Engineers Comments Regarding Surface Water Drainage

Application Reference:	BR/24/26/PL	Reviewer Reference:	ADC/EXT4b
Planning Officer:	Simon Davis	Date of Review:	21/09/2026
Site Name:	Tesco Superstore Shripney Road Bognor Regis PO22 9ND		
Application Description:	Installation of single storey raised car park deck together with site alterations, car park reconfiguration, new access into car park, drainage alterations, creation of new drainage outfall, landscaping and other associated works.		
Assessment Number:	2 of 1

Drawing Number: **30268440-ARC-P01-XX-DR-LA-00004** Revision: **7**

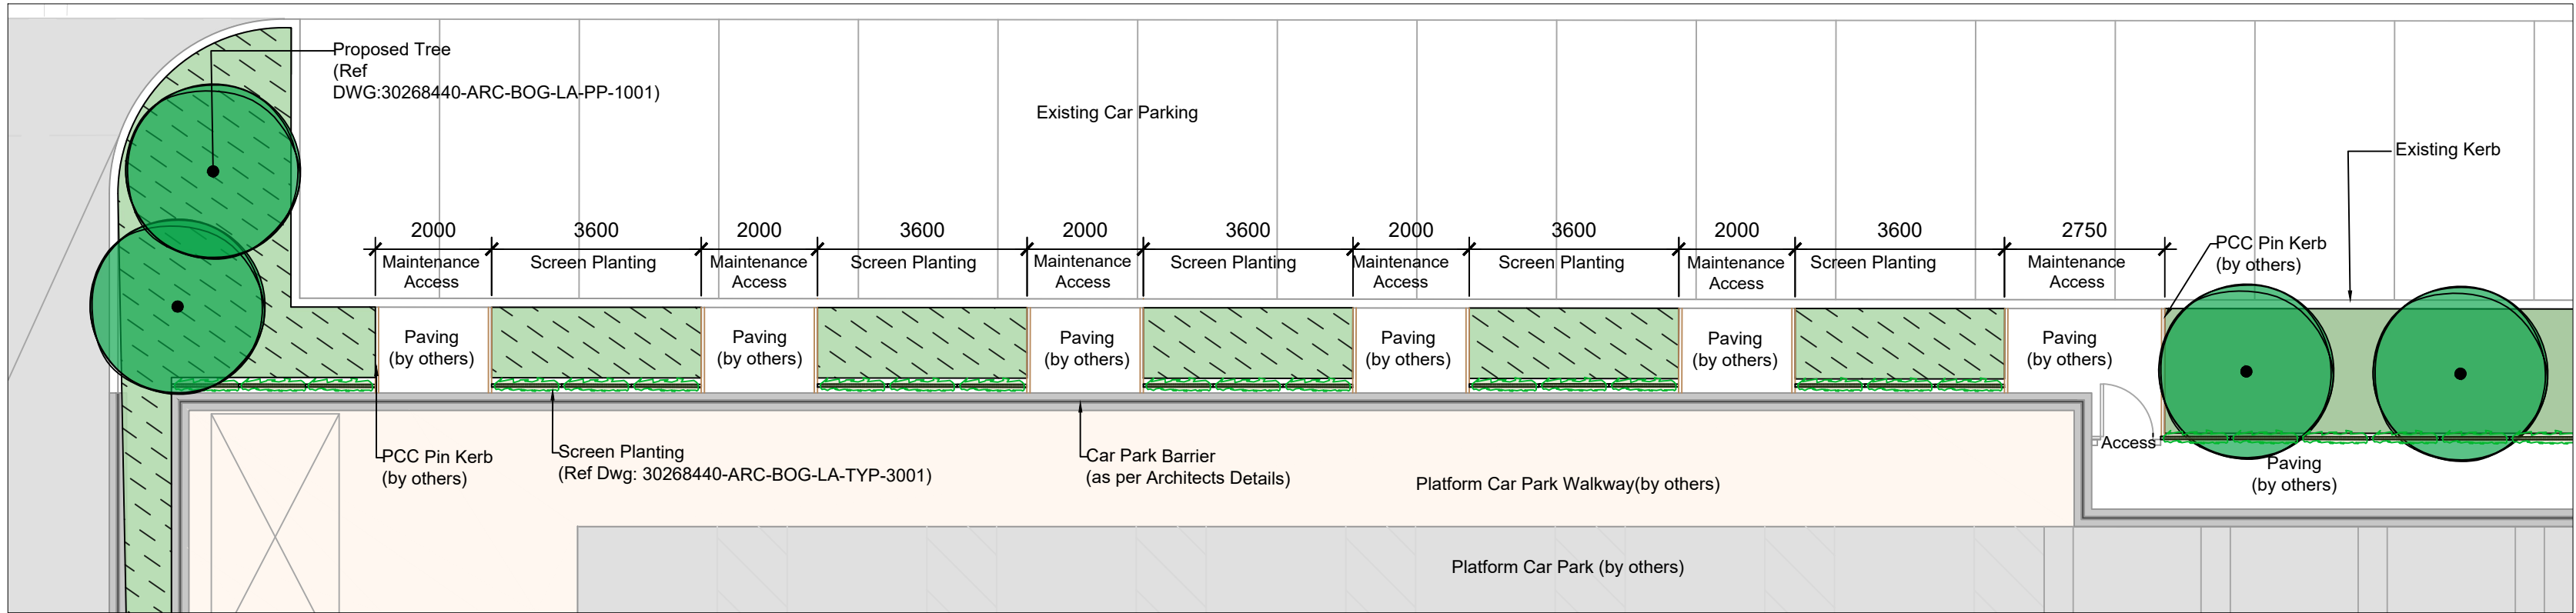
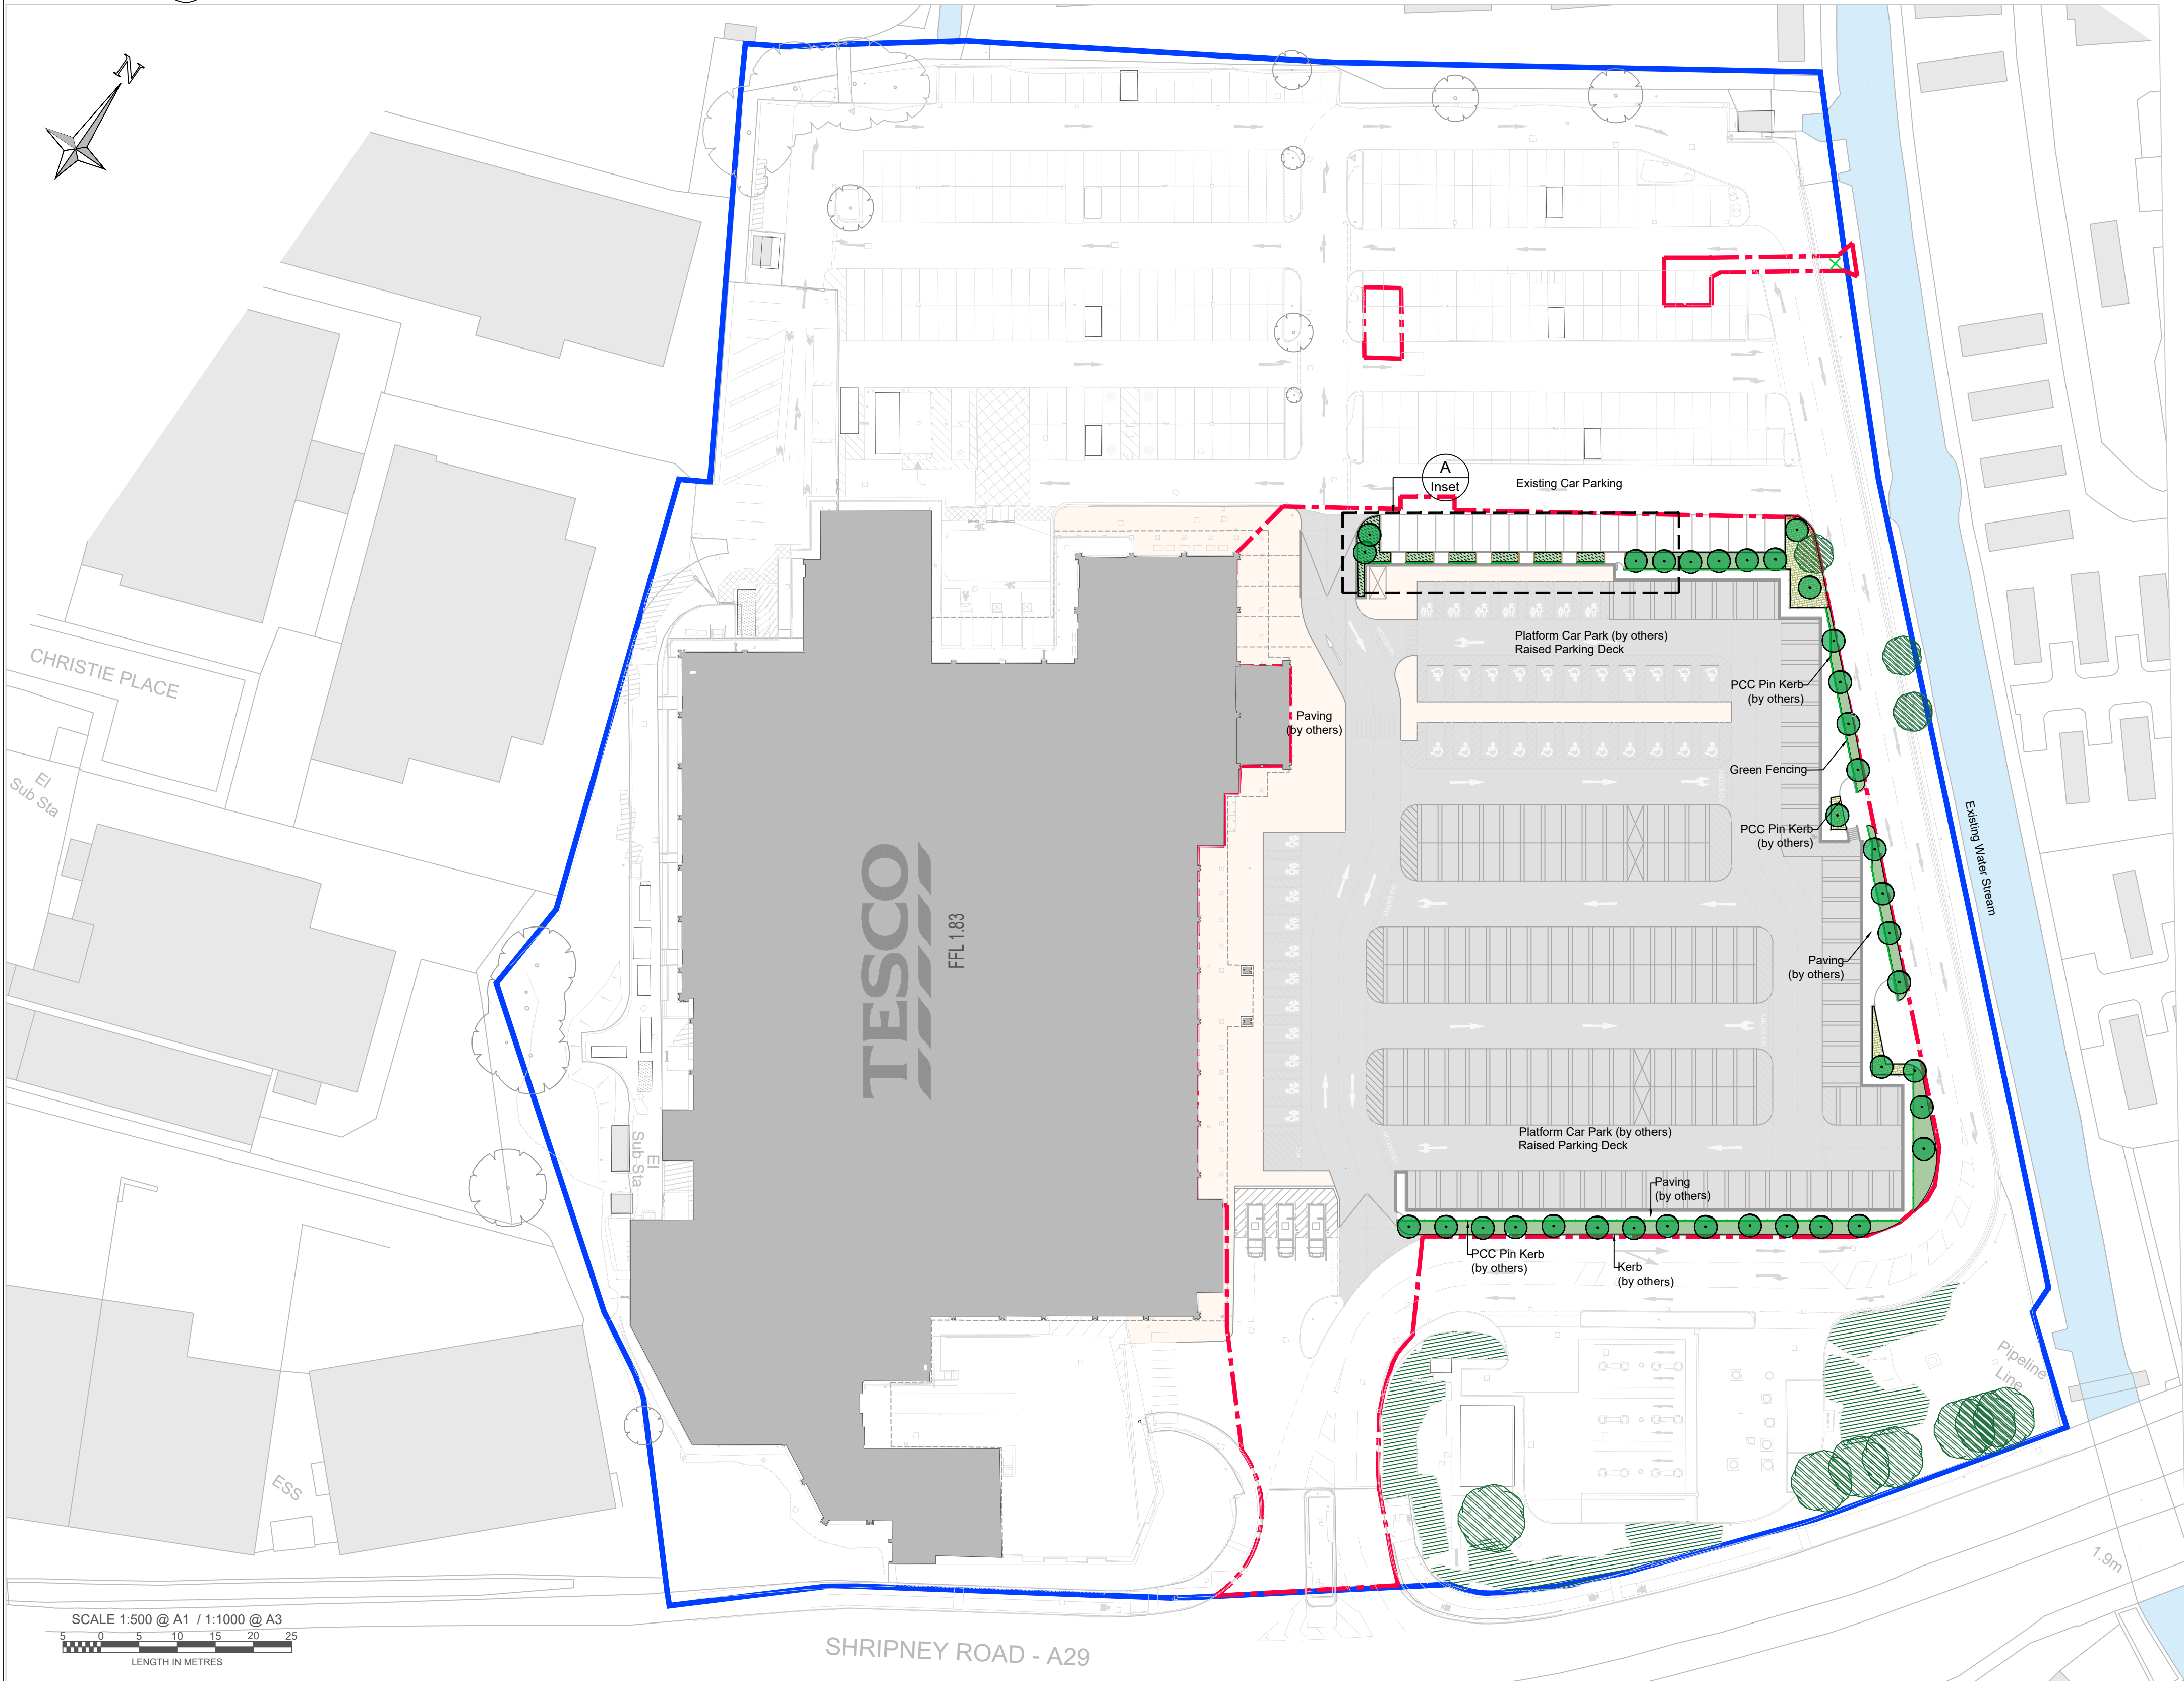
5.1. The applicant has clarified that no above ground SuDS features are proposed and that the proposed landscaping does not form part of the SuDS strategy. Any inconsistencies between the plans are therefore inconsequential. However, the lack of any form of amenity offered by the SuDS results in an unavoidable objection.
